An  
Bord  
Pleanála

## Memorandum ABP-317660-23

**To:** Board  
**From:** Fiona Fair, Senior Planning Inspector  
**Re:** Oral Hearing Recommendation for application under Section 51(2) of the Roads Act 1993 Application no. ABP-317660-23  
**Date:** 16<sup>th</sup> October 2024

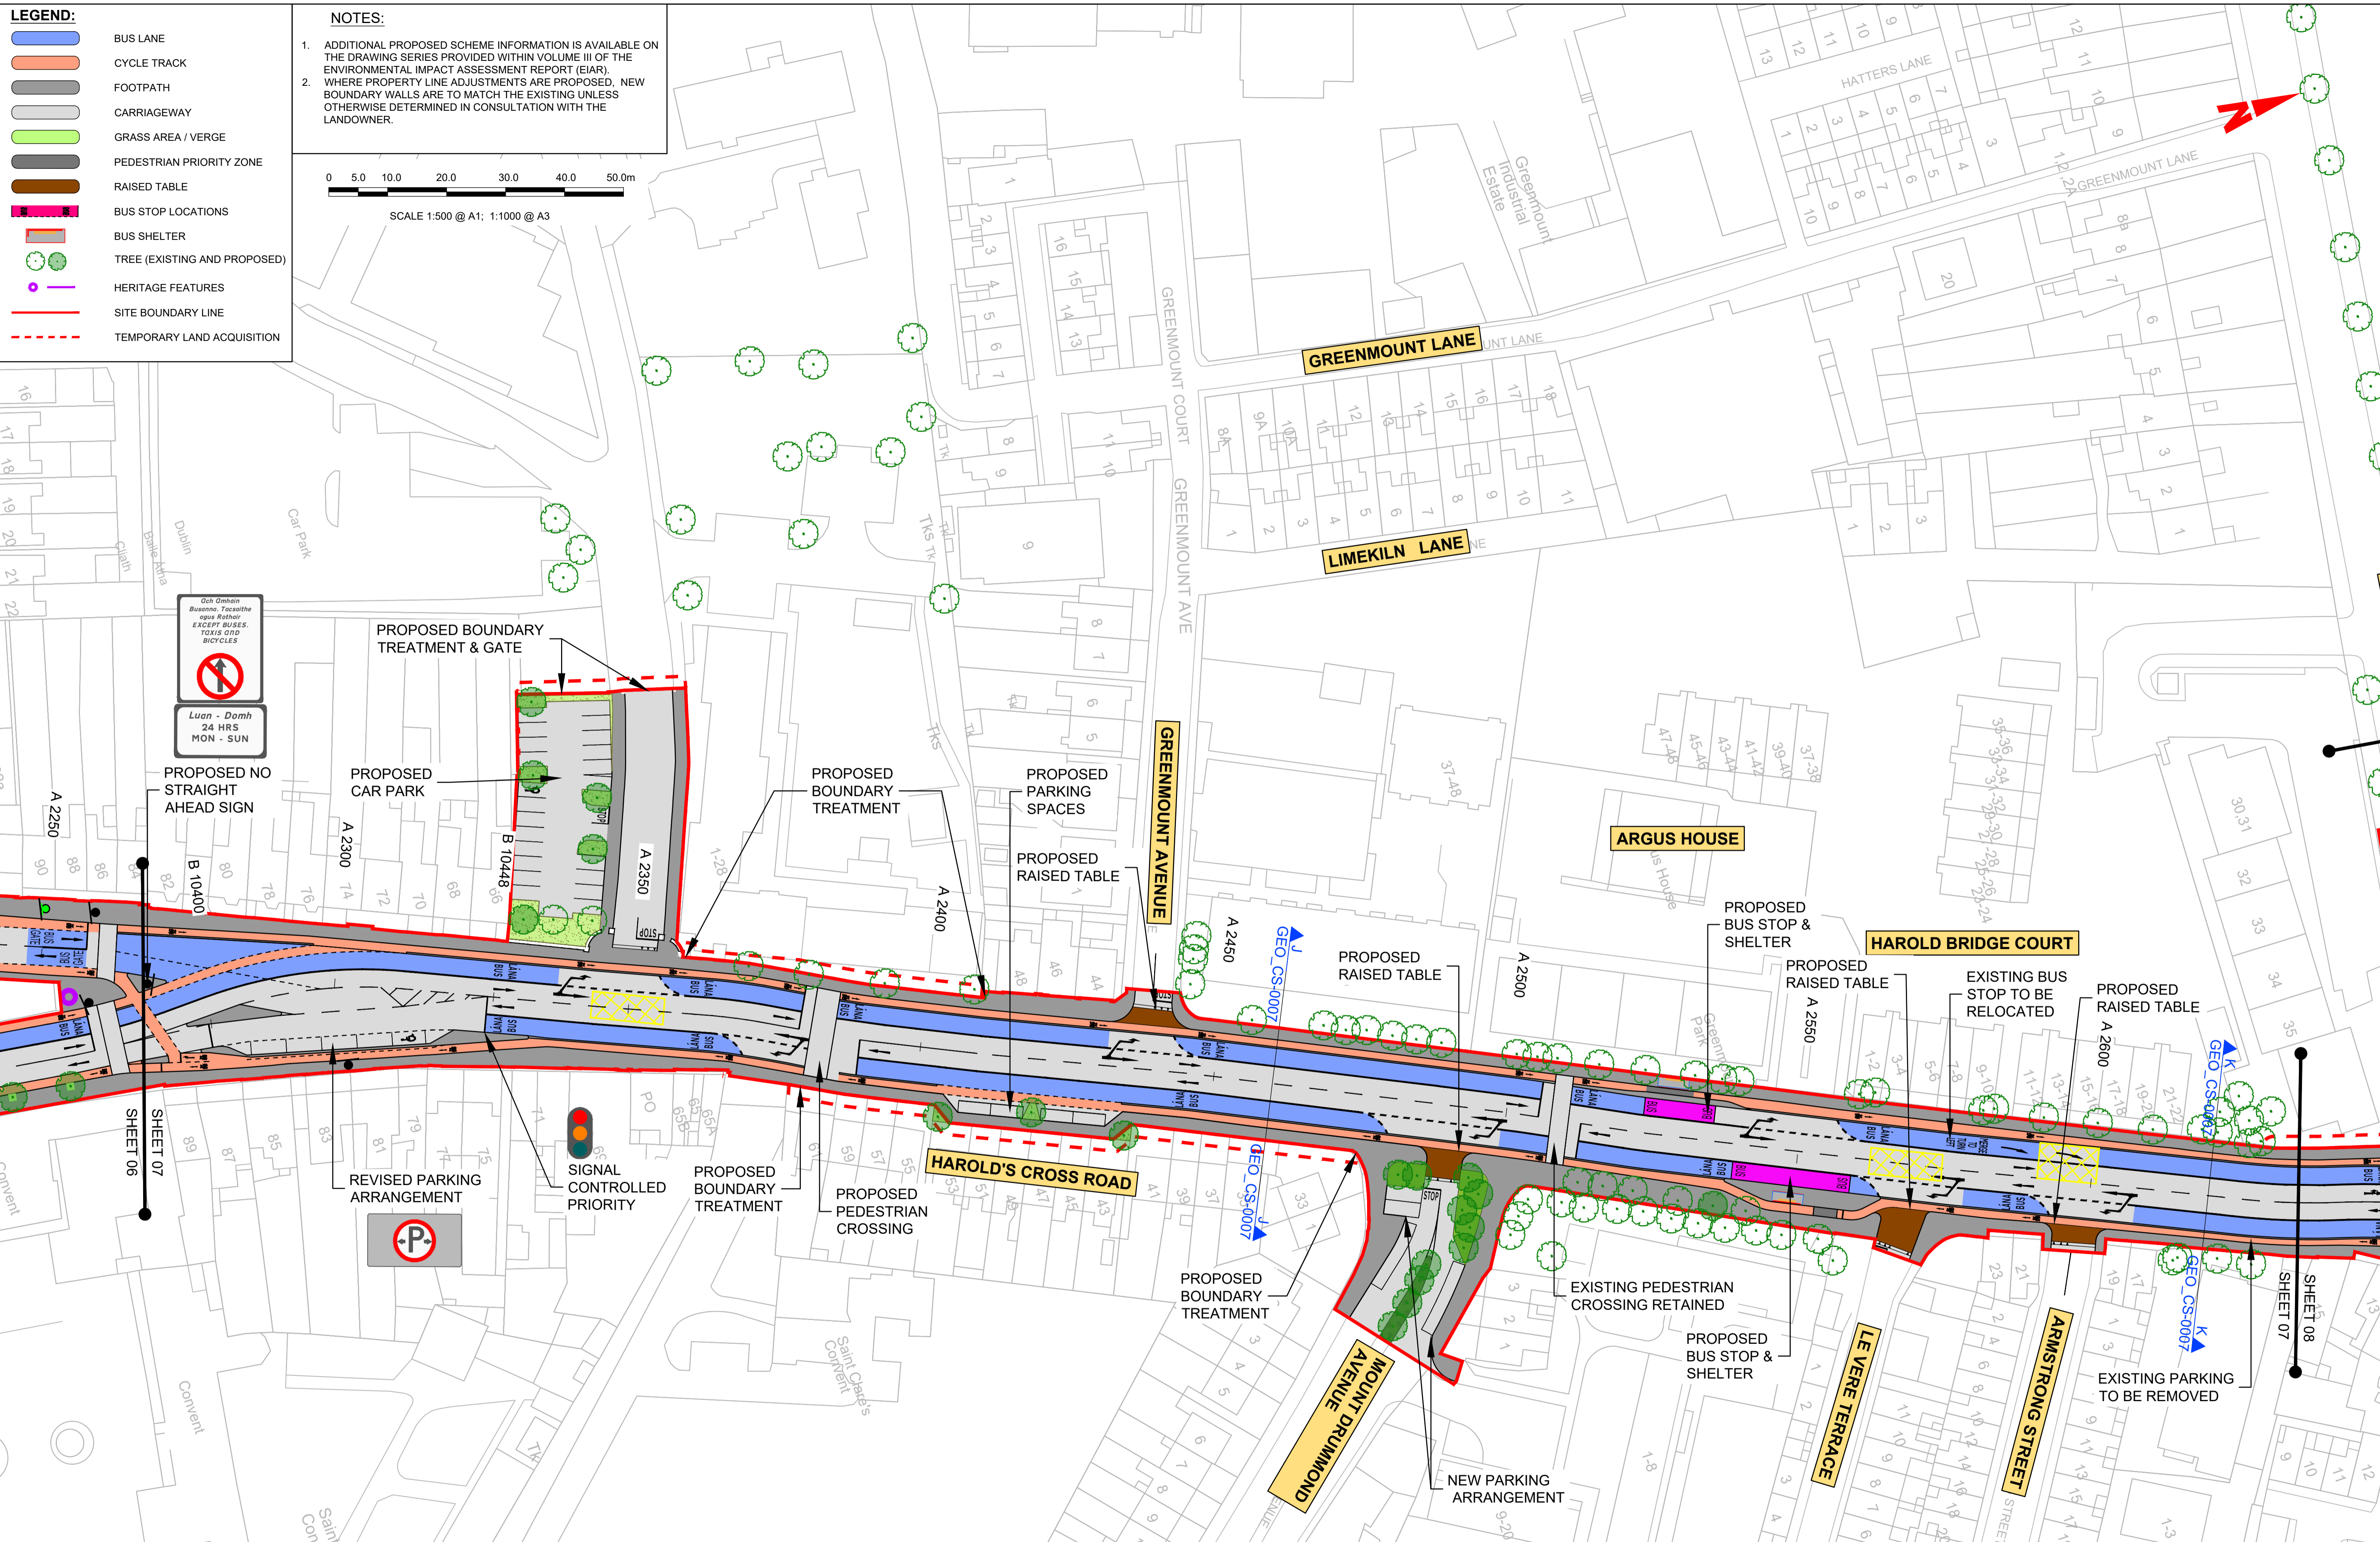
- Bus shelters impact on the width of footpaths and should only be proposed where there is sufficient space to physically accommodate them and passengers congregating in their vicinity. It is unclear if there is sufficient width to the footpaths in some locations where bus shelters are proposed e.g. the proposed south bound bus stop and bus shelter on Harold's Cross Rd to the west side of Harold's Cross Park, {Sheet 06}, and the proposed north bound bus stop and bus shelter on Clanbrassil St Upper, (Sheet 08).

- Request that by condition, full details of the design and type of each bus shelter for each location shall be submitted to, and agreed in writing with, the planning authority prior to commencement of development
